**WEST SUSSEX COUNTY COUNCIL
STRATEGIC PLANNING CONSULTATION**

SUBJECT: BN/69/16/PL - 5 no. dwellings comprising 2 no. 4- bed houses, 2 no. 3- bed houses and 1 no. 3- bed bungalow, with access and ancillary works.

Land East of Toll Cottage, Lake Lane, Barnham, West Sussex, PO22 0AD

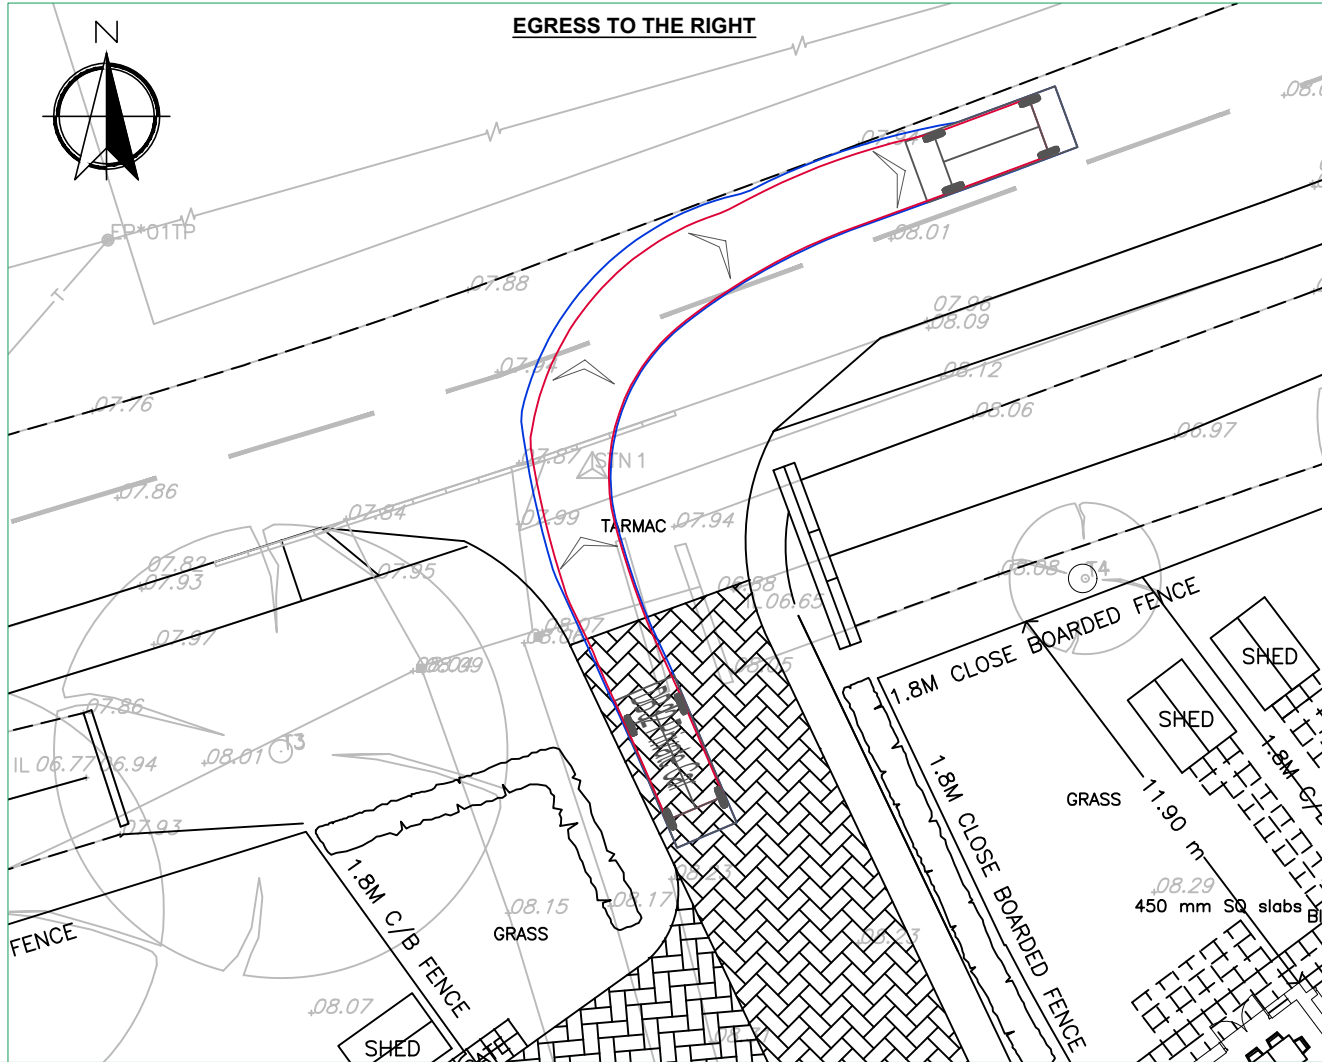
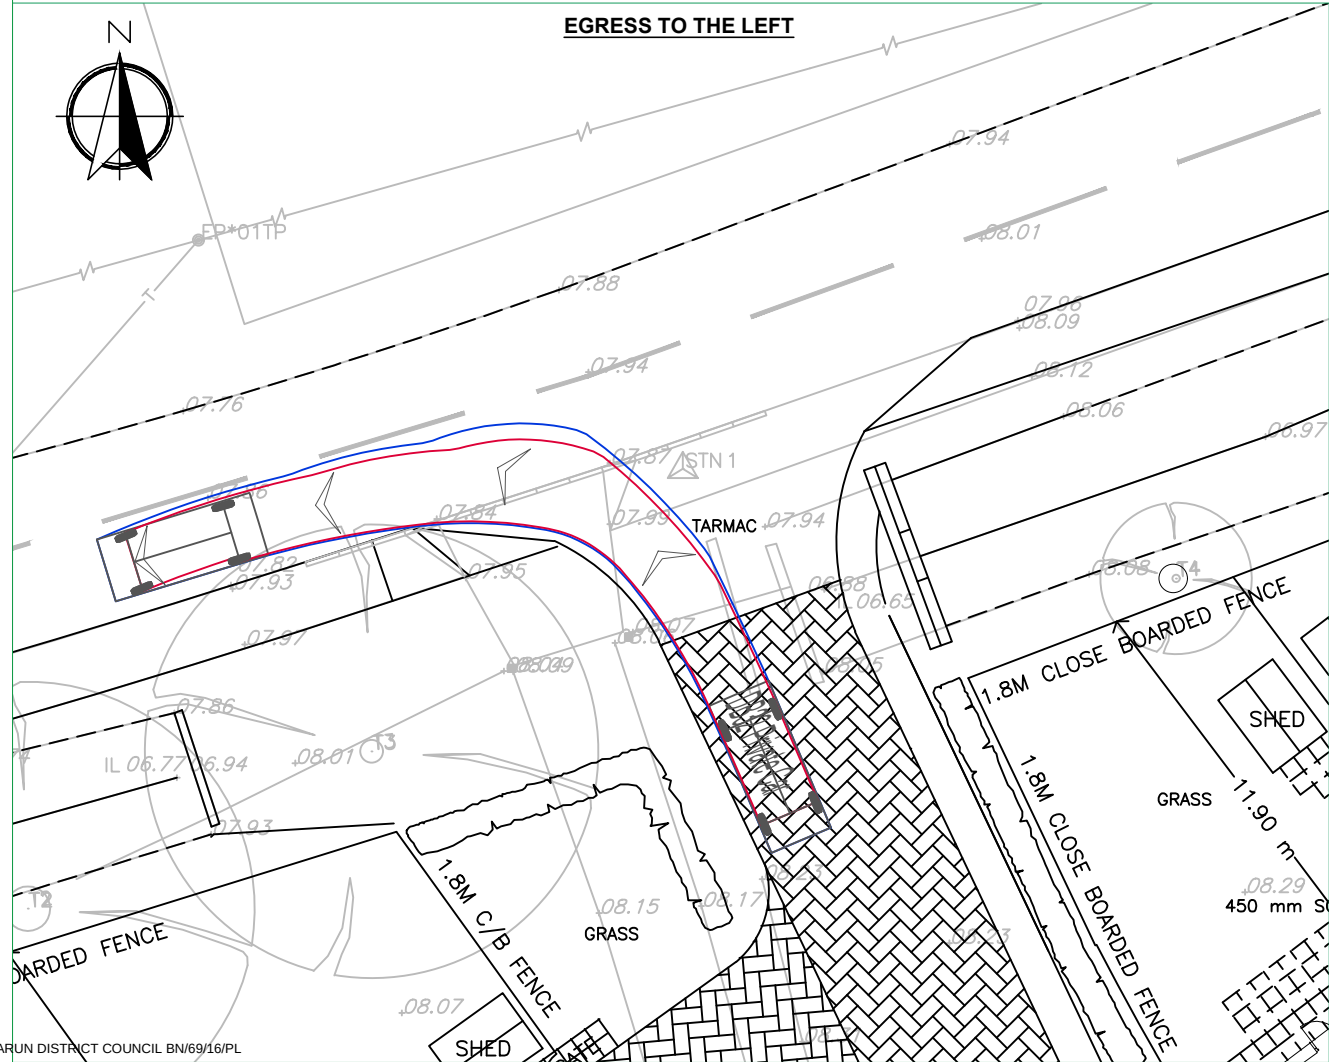
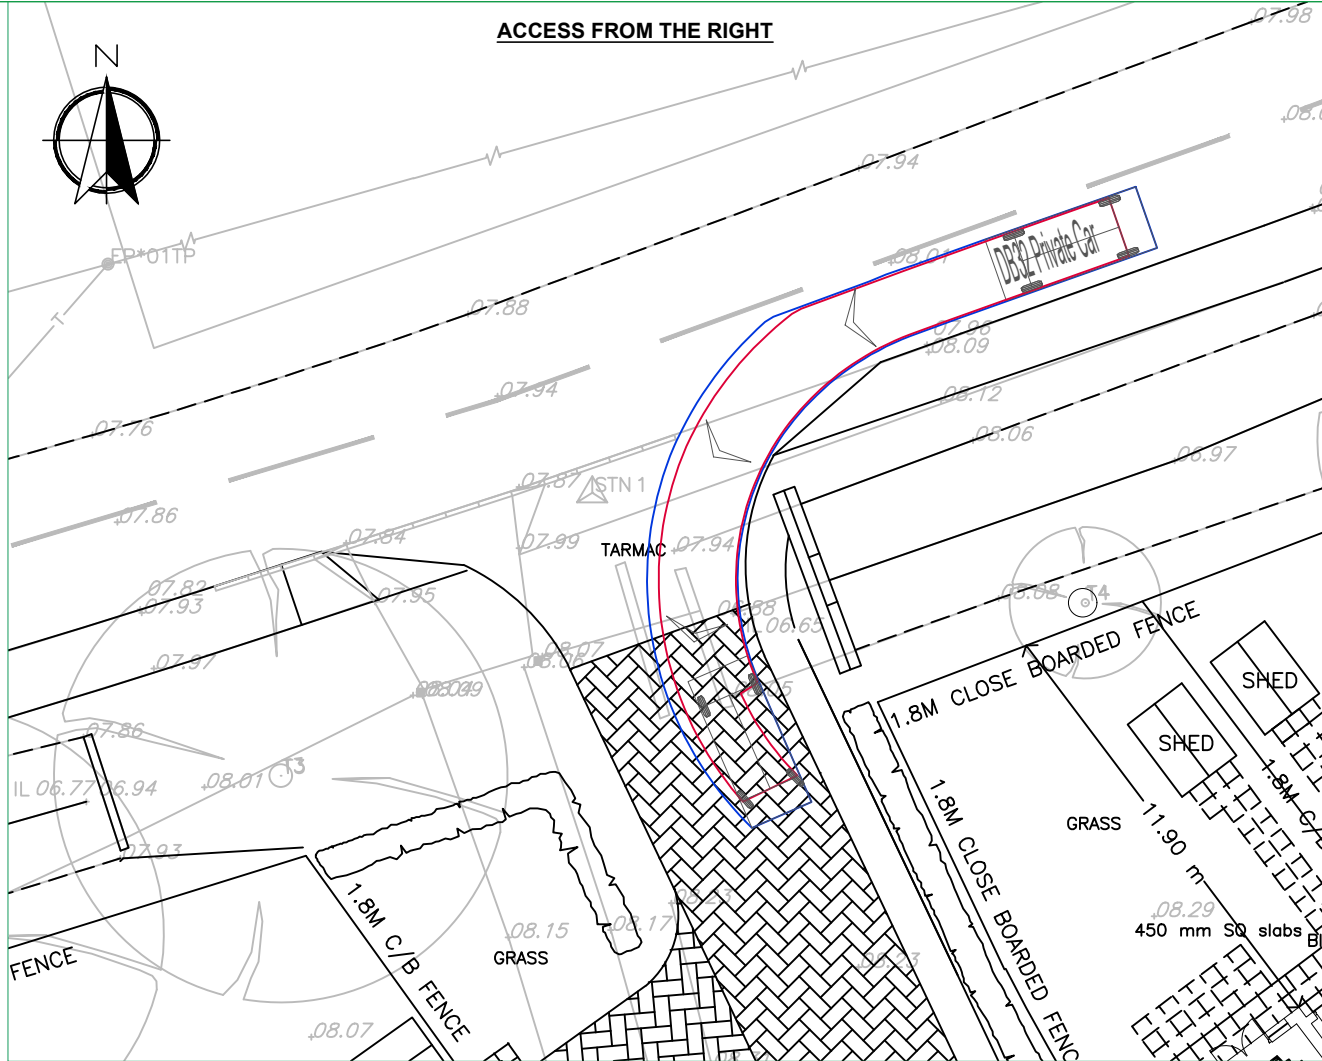
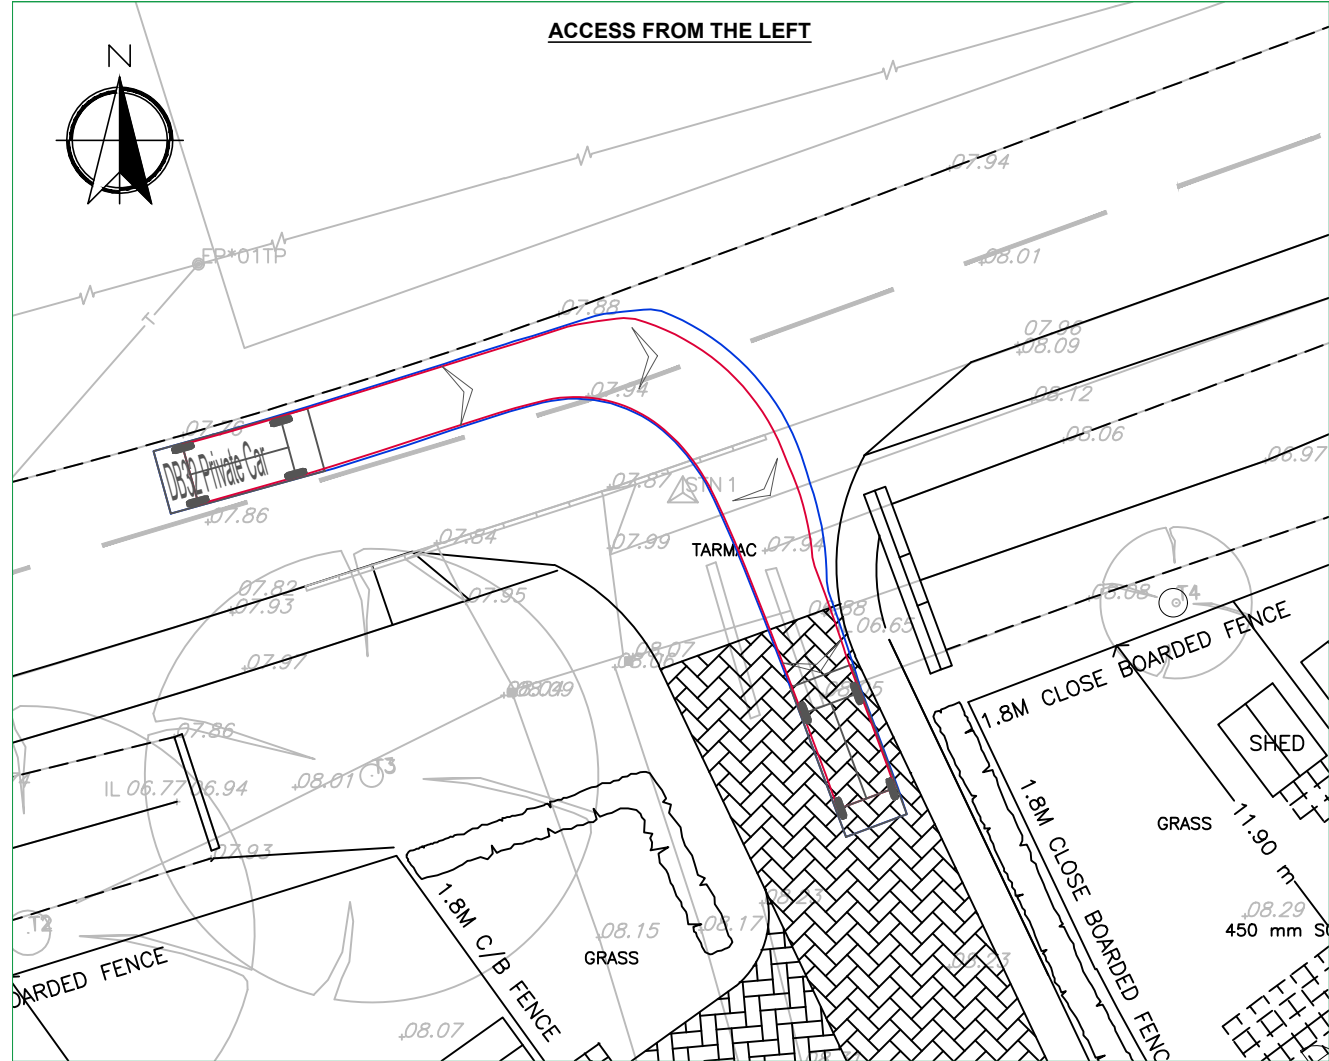
Revised Swept Path Analysis plans (Rev B) indicate the achievability of cars, Fire Tender and Refuse Vehicle to enter, turn on site utilising the turning head provided, and egress on to Lake Lane. The LHA do not raise any concerns in relation to access for servicing vehicles.
